PROPOSED SITE LAYOUT / GATE ELEVATION

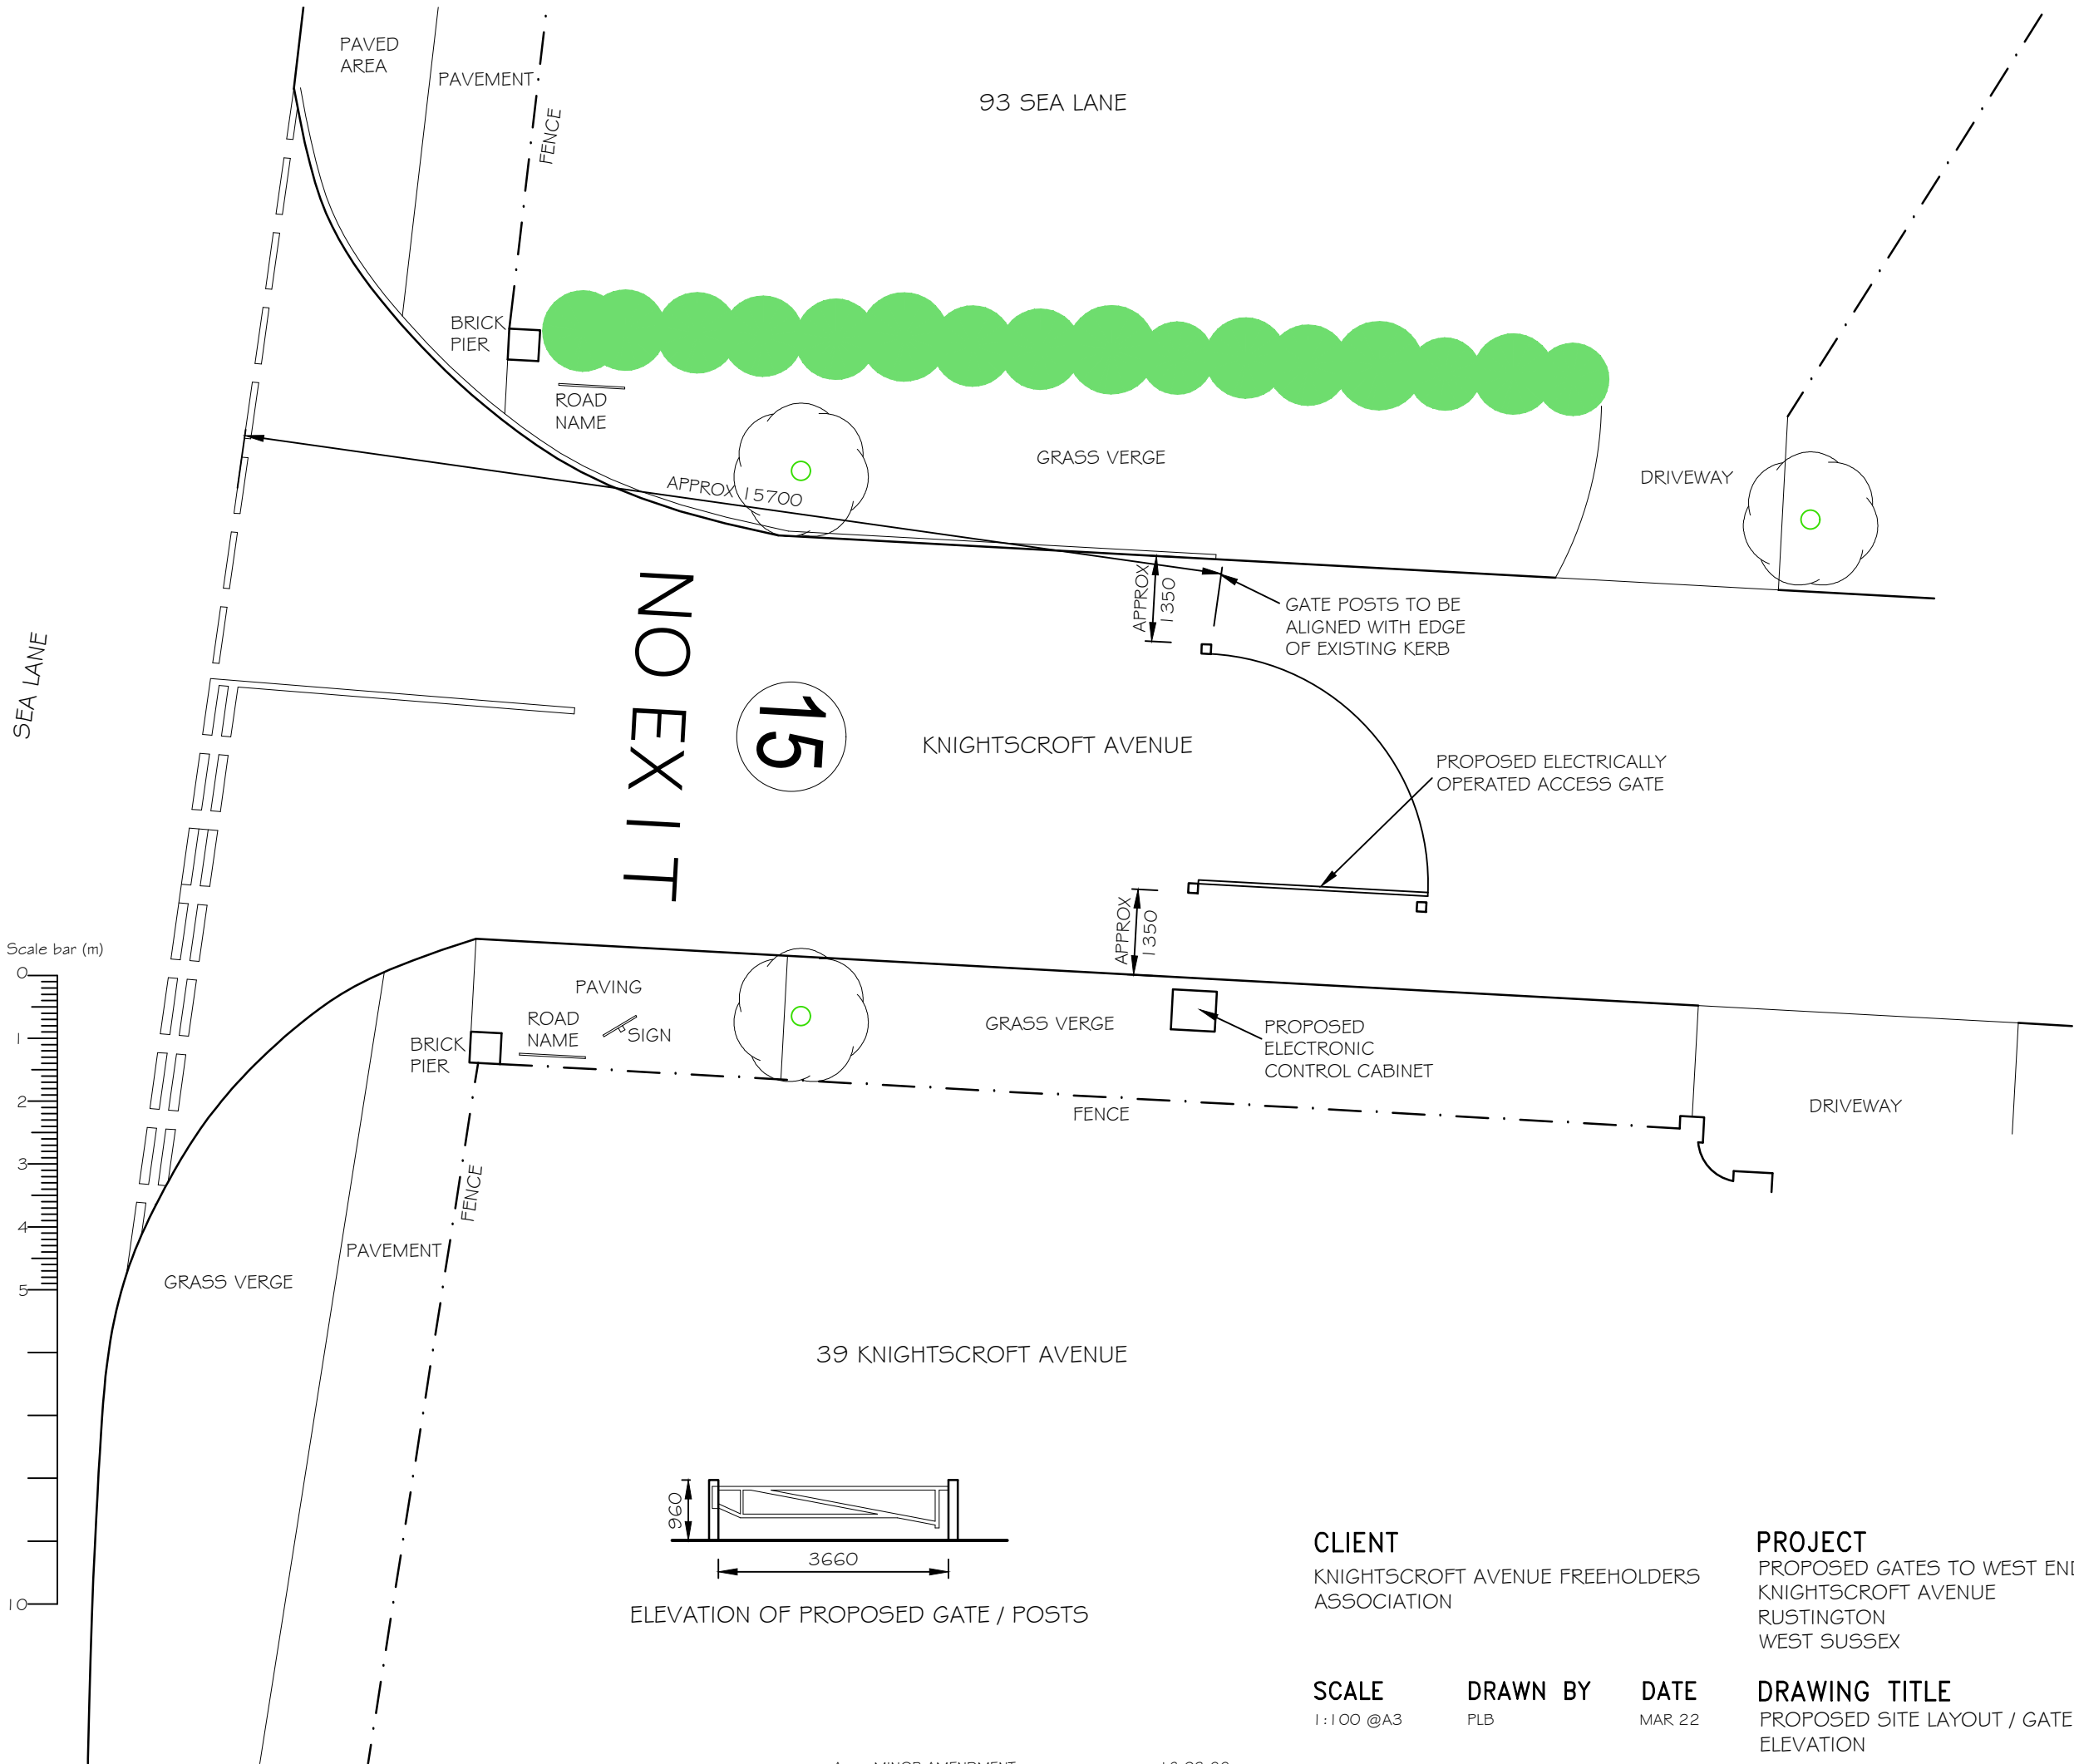
To say that the proposed new gate, as depicted in the plans, is located a suitable distance from the junction with Sea Lane where as in fact the space would barely accommodate the average delivery van is completely misleading. This together with the fact that the gate will narrow the road to a single lane for the combined accessing and exiting of Knightcroft Avenue will further exacerbate a volatile and potentially dangerous set of circumstances.

However, lawfulness, planning, and majority votes aside, the only household such a proposal really affects is mine. The proposed gate is situated directly outside my house, which means every temporary roadblock, traffic altercation and road accident throughout the day and night will impinge on my quality of life. Turning in the road will inevitably churn up the grass verges and the proposed gate will mean family and friends will not be able to park by the curb
